# CITY OF ALBUQUERQUE

RE: **Maverick at University & Menaul**  
**1901 Menaul NE**  
**Grading Plan Stamp Date: 1/29/20**  
**Drainage Report Stamp Date: 12/11/19**  
**Hydrology File: H15D068**

**RE: MAVERIK AT UNIVERSITY & MENAUL  
GRADING PLAN & DRAINAGE REPORT RESPONSE TO COMMENTS  
ENGINEER'S STAMP DATE 12/11/19 (H15D068)**

NOTE: SEE SHT C11 FOR DETAILS ON WALL & FOOTING DIMENSIONS
SECTION A-A
NTS

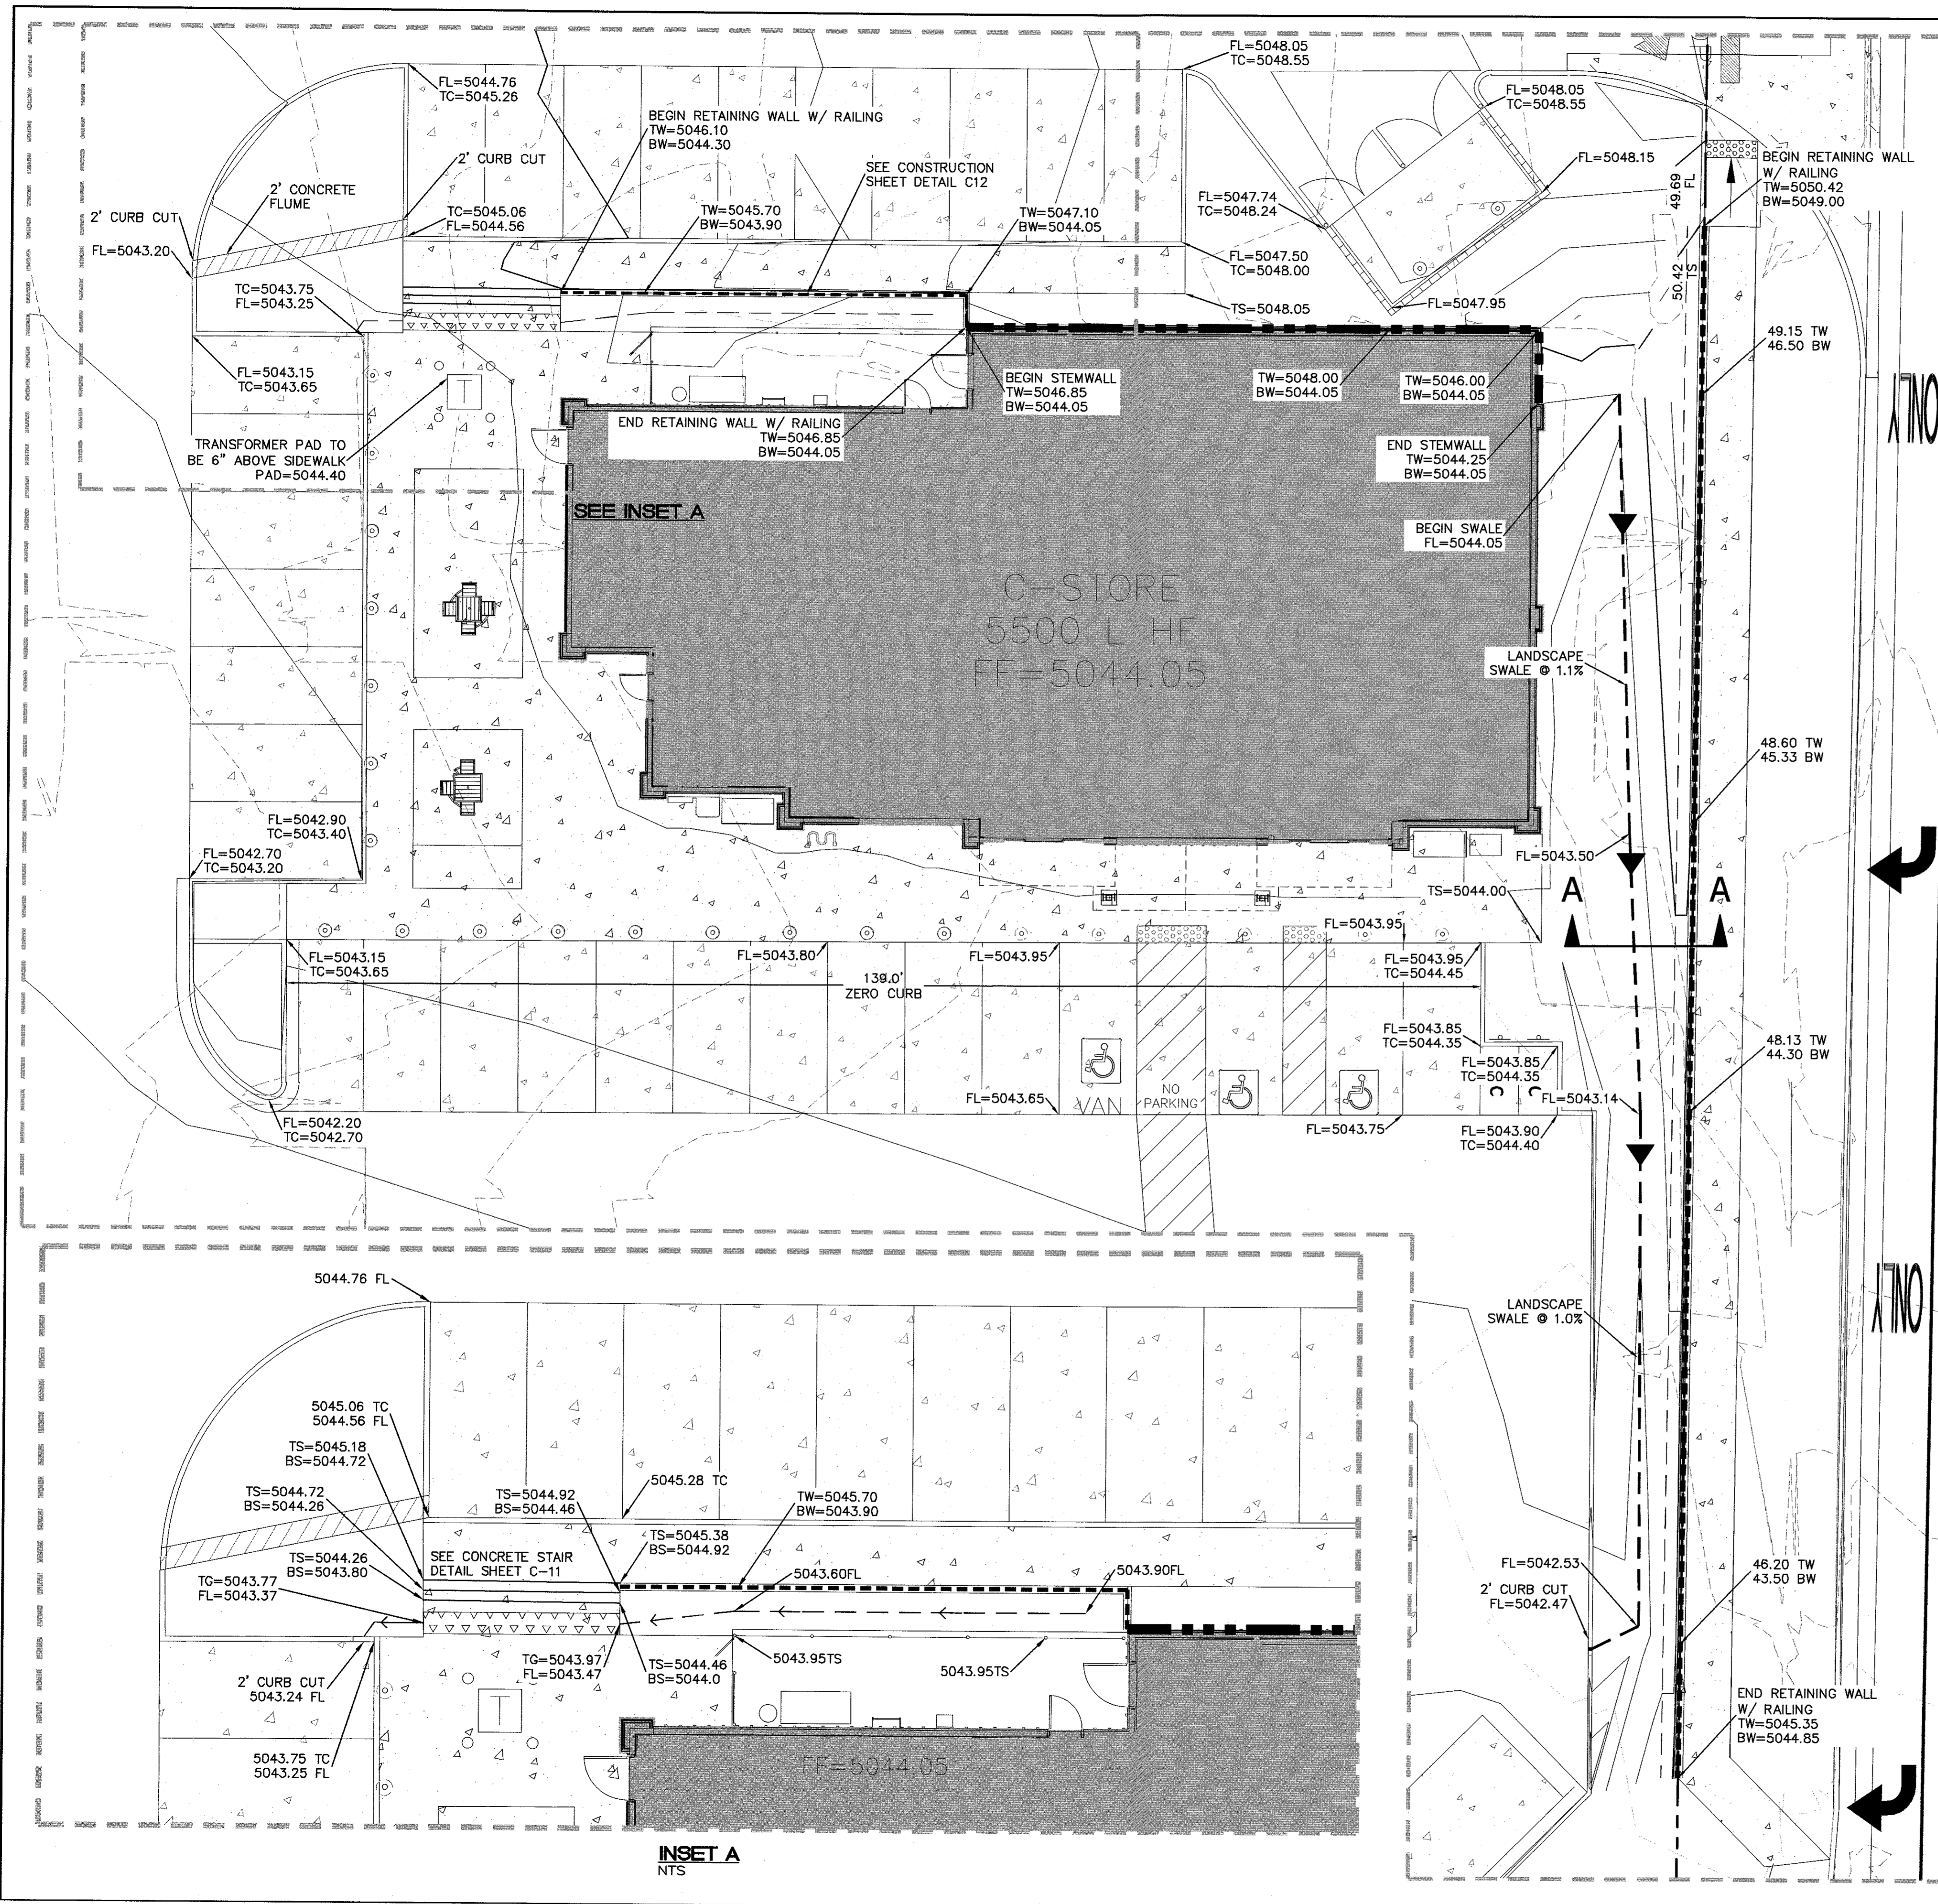
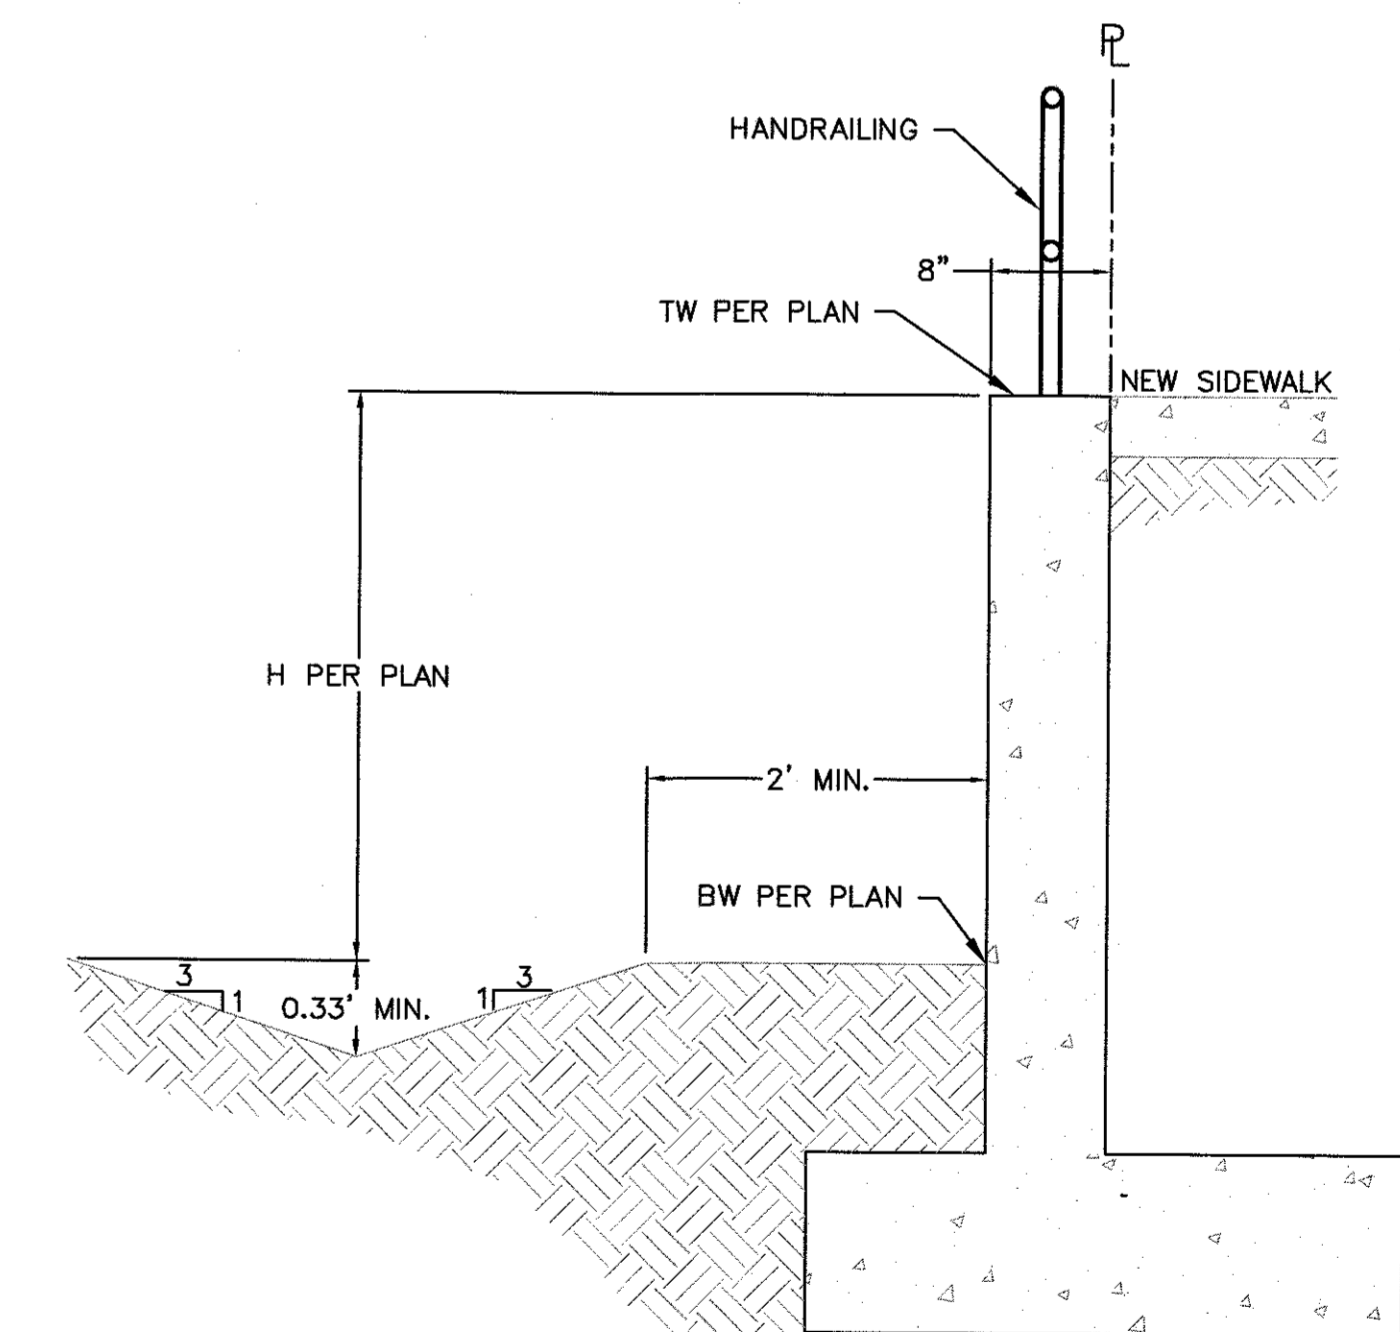
1. Provide a Revocable Permit and Slope Easement (measured at a 3:1 slope from top of wall to bottom of wall) for the retaining wall encroaching on University. Final recorded documents can be provided at CO, but they need to be initiated now. Turn in the documents to DRC on the 4<sup>th</sup> floor for routing and then provide a copy along with a DTIS sheet when resubmitting for building permit approval. There is no resubmittal fee for this action; please include a copy of this letter when resubmitting to receive the reduced fee.

**Response: The slope easement has been completed and recorded and is attached with this letter. A 12'-wide easement has been established in the location of the proposed retaining wall adjacent to University Blvd. This retaining wall has been shifted to the west to be away from the property line and using an L-footing. The cross section A-A of this wall has been updated on Sheet C6 and an L-Footing retaining wall detail has been added to Detail Sheet C9.**
